Examining Authority
National Infrastructure Planning
The Planning Inspectorate

17 February 2016
Dear Sir/Madam

TRITON KNOLL ELECTRICAL SYSTEM – REF 10031863

WRITTEN RESPONSE TO THE THIRD WRITTEN QUESTIONS

Figure 6 *Indicative Trenched 132kV Cable Circuit Plan - Addendum A- Further detail regarding the TKES corridor (Appendix 29, Part 2 of the Applicant's response to Deadline 4 [REP4-057])*

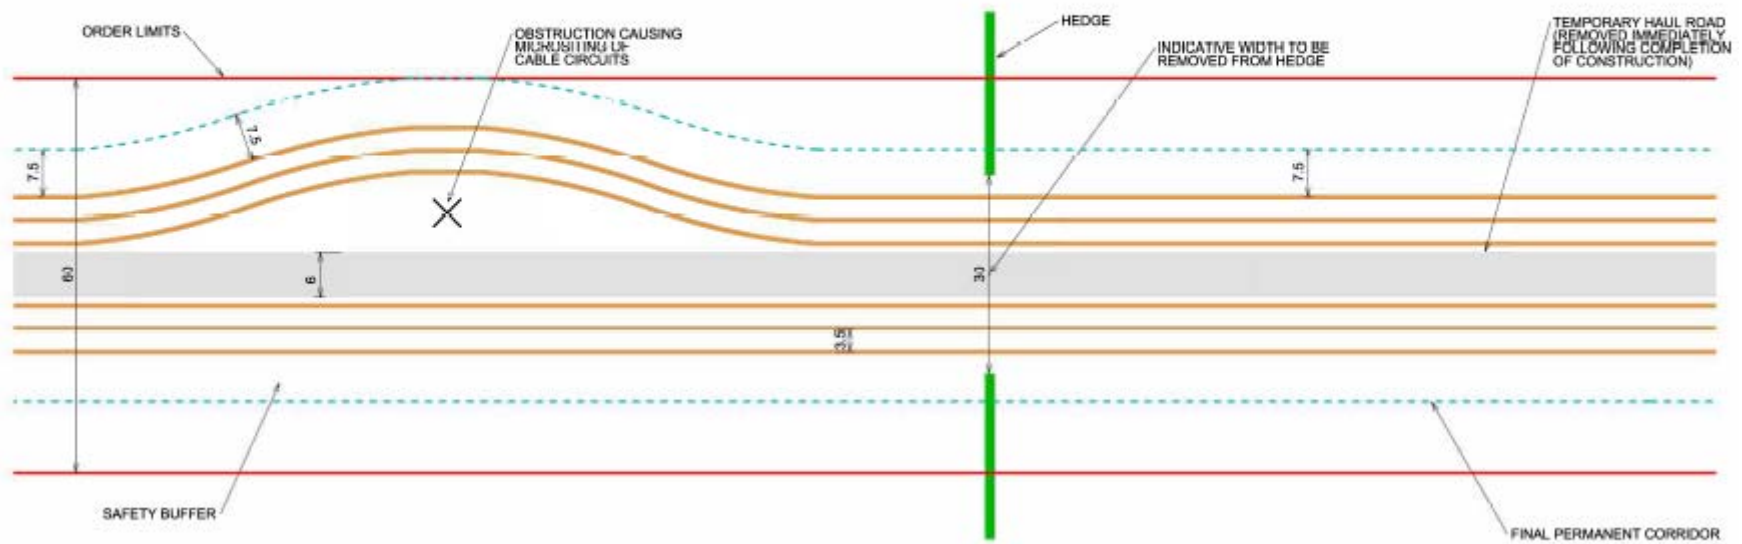
Excavating the cable trenches directly through the middle of the field and to a depth that will penetrate the clay substrate is a very high risk strategy. If restoration were to fail due to admixing of the clay or cracks caused by settlement or shrinkage over the cables due to warmth, water will be lost. Furthermore it would be very difficult to find and rectify such issues with further risk to the habitat.

I find it very difficult to understand how the applicant has reached the conclusion that digging 6 deep trenches directly through the middle of a known breeding wader site is acceptable. It is not tolerable and poses a much higher risk to either of the proposed alternatives that are supported by LWT and Mr Spence. Neither is it consistent with what should be expected of a company required to protect the environment on a project of this scale.

A number of points have been raised by the applicant over technical issues regarding the use of a trenchless crossing, the preferred option. It has been proved that a trenchless method is a perfectly viable methodology. Adopting this approach has very low risk of compromising the current very successful water retention and with the added advantage of minimal habitat disturbance if carried out with the correct timing.

There is also the perfectly practical alternative of placing the open cuts technique within a 40m wide corridor along the road side. This has a number of significant advantages over a trenching operation proposed directly through the middle of the site including:

The aim must be to reduce the environmental risk to the wet grassland and associated breeding waders by adopting either a trenchless crossing or modest diversion to the field edge.
